WOODMEN HILLS METROPOLITAN DISTRICT REGIONAL WATER RECLAMATION FACILITY GRADING AND EROSION CONTROL PLAN

WHMD RWRf STORM IMPROVEMENTS
EL PASO COUNTY, COLORADO
GEC PLANS
COVER SHEET

WHMD RWRF STORM IMPROVEMENTS
EL PASO COUNTY, COLORADO
GEC PLANS
GEC INITIAL PLAN

GEC INITIAL PLAN

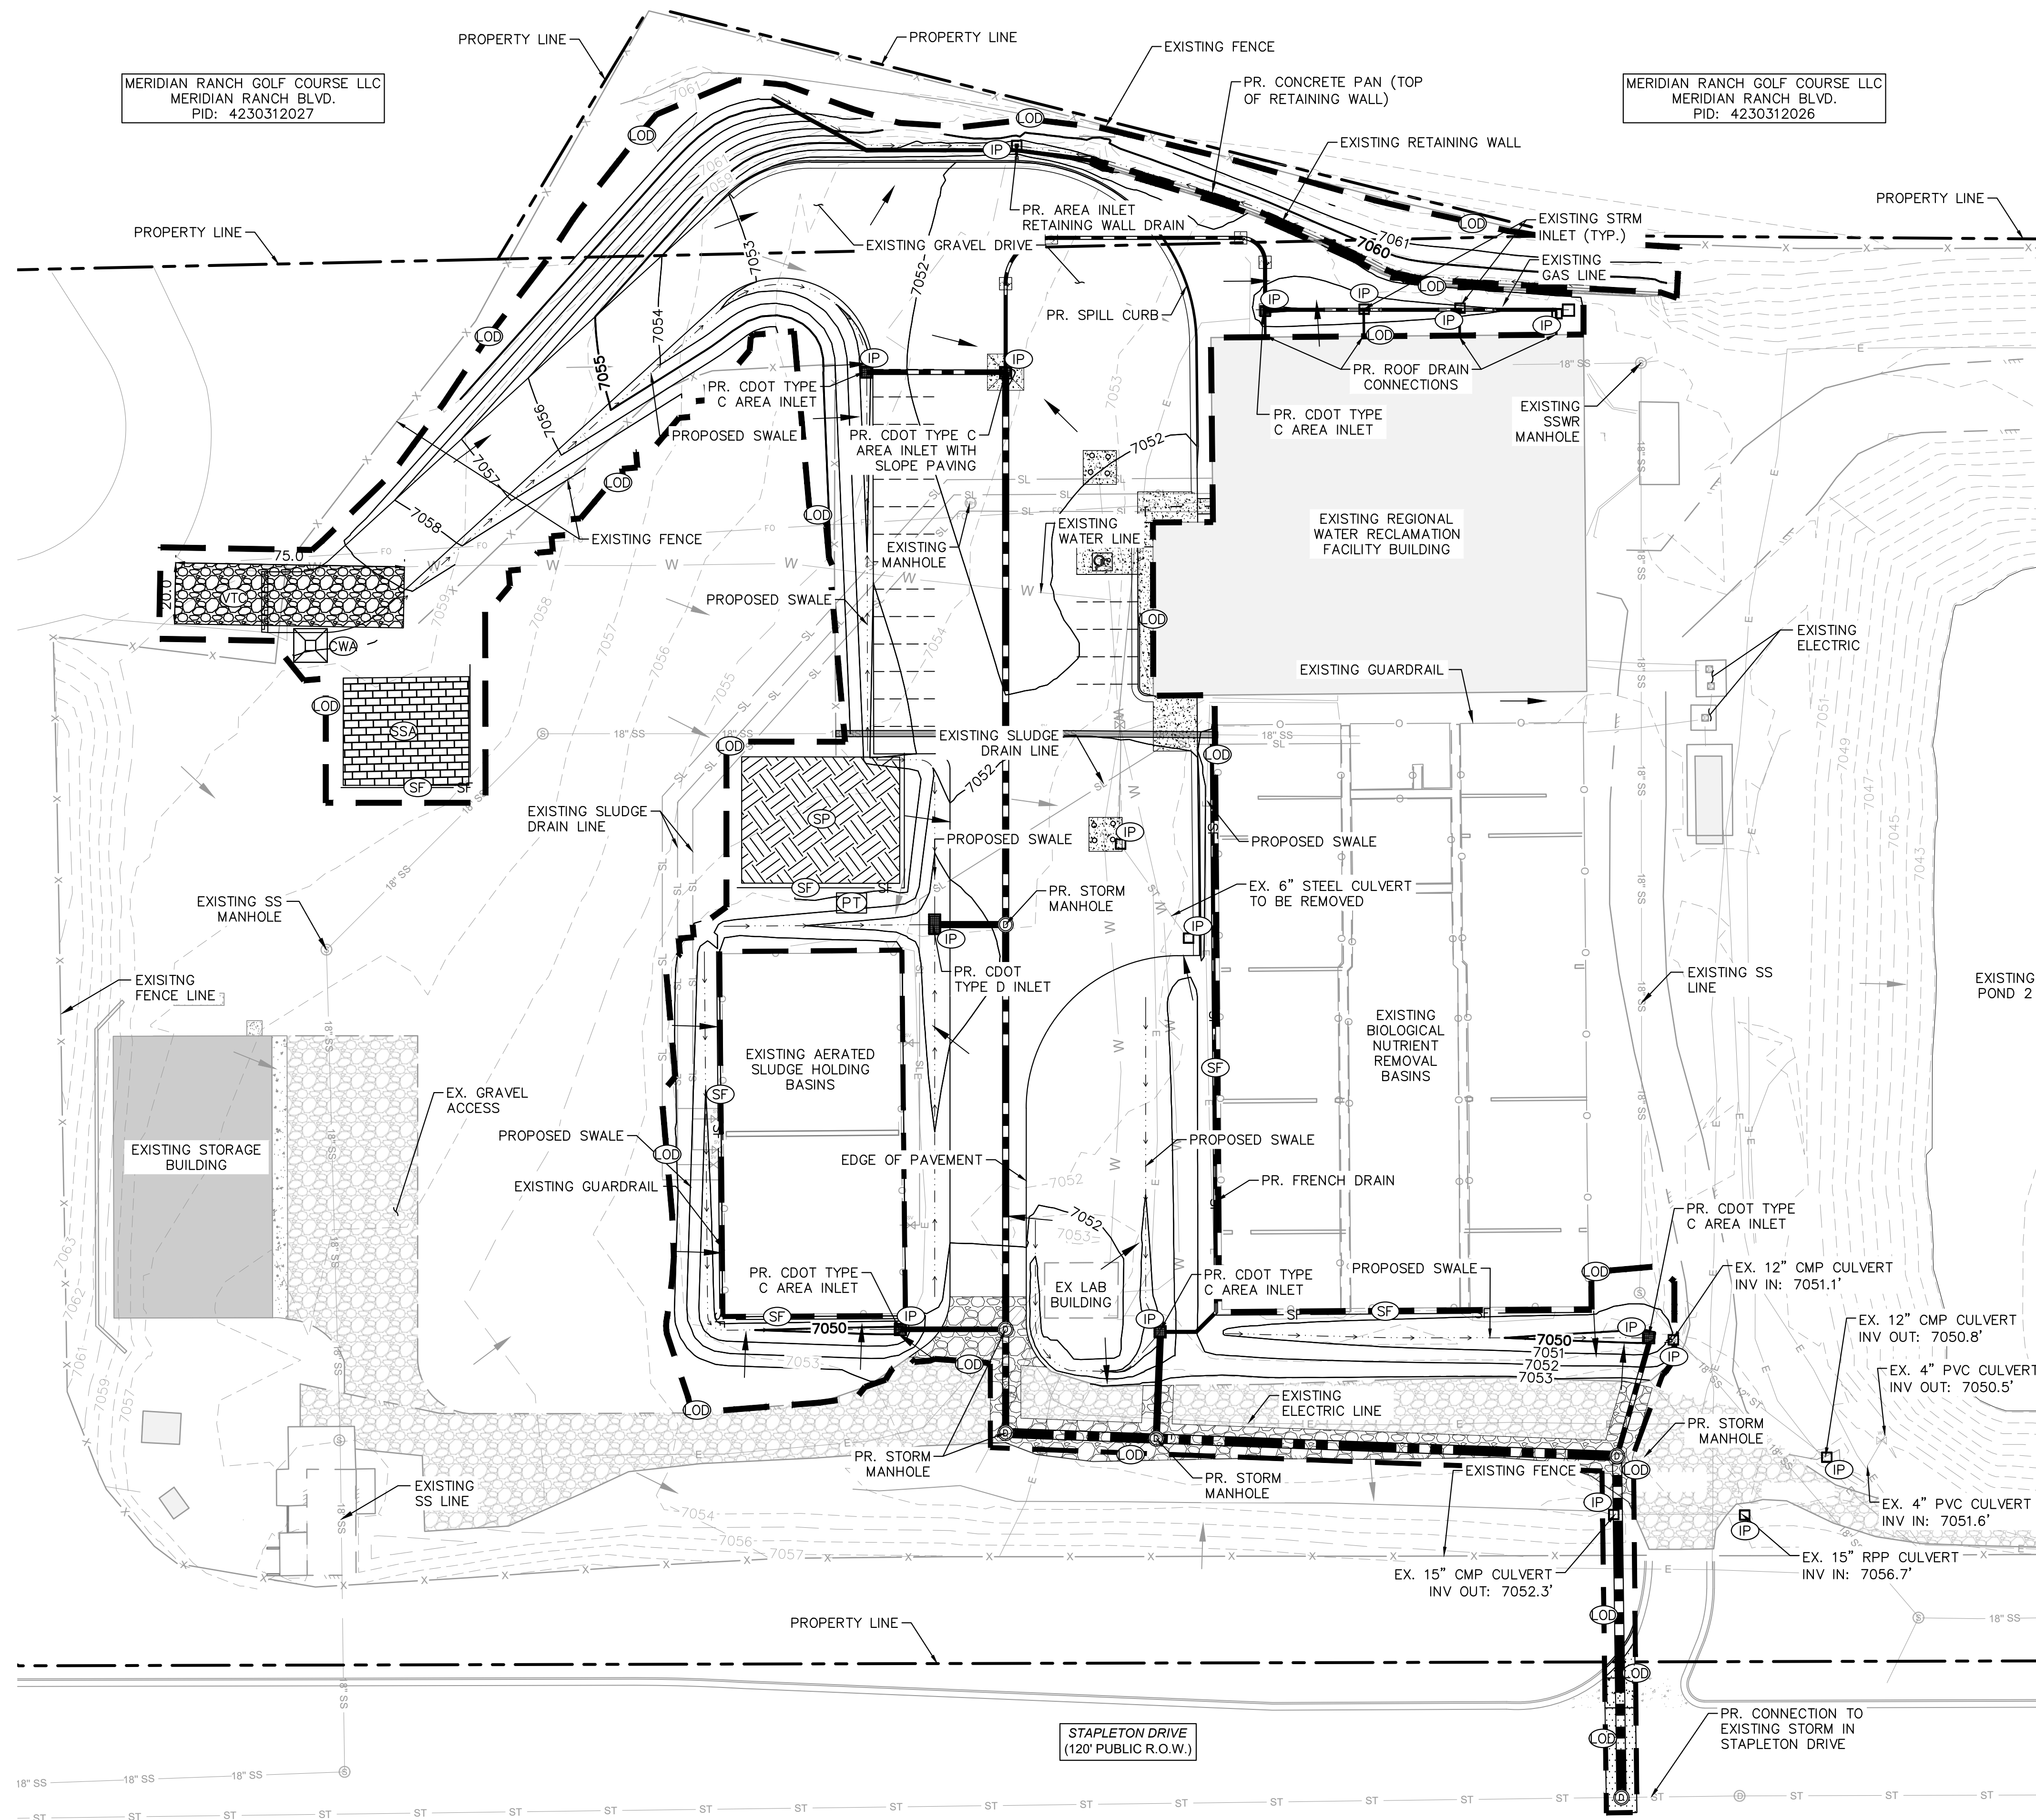
replace all mentions of Adams County with El Paso County.
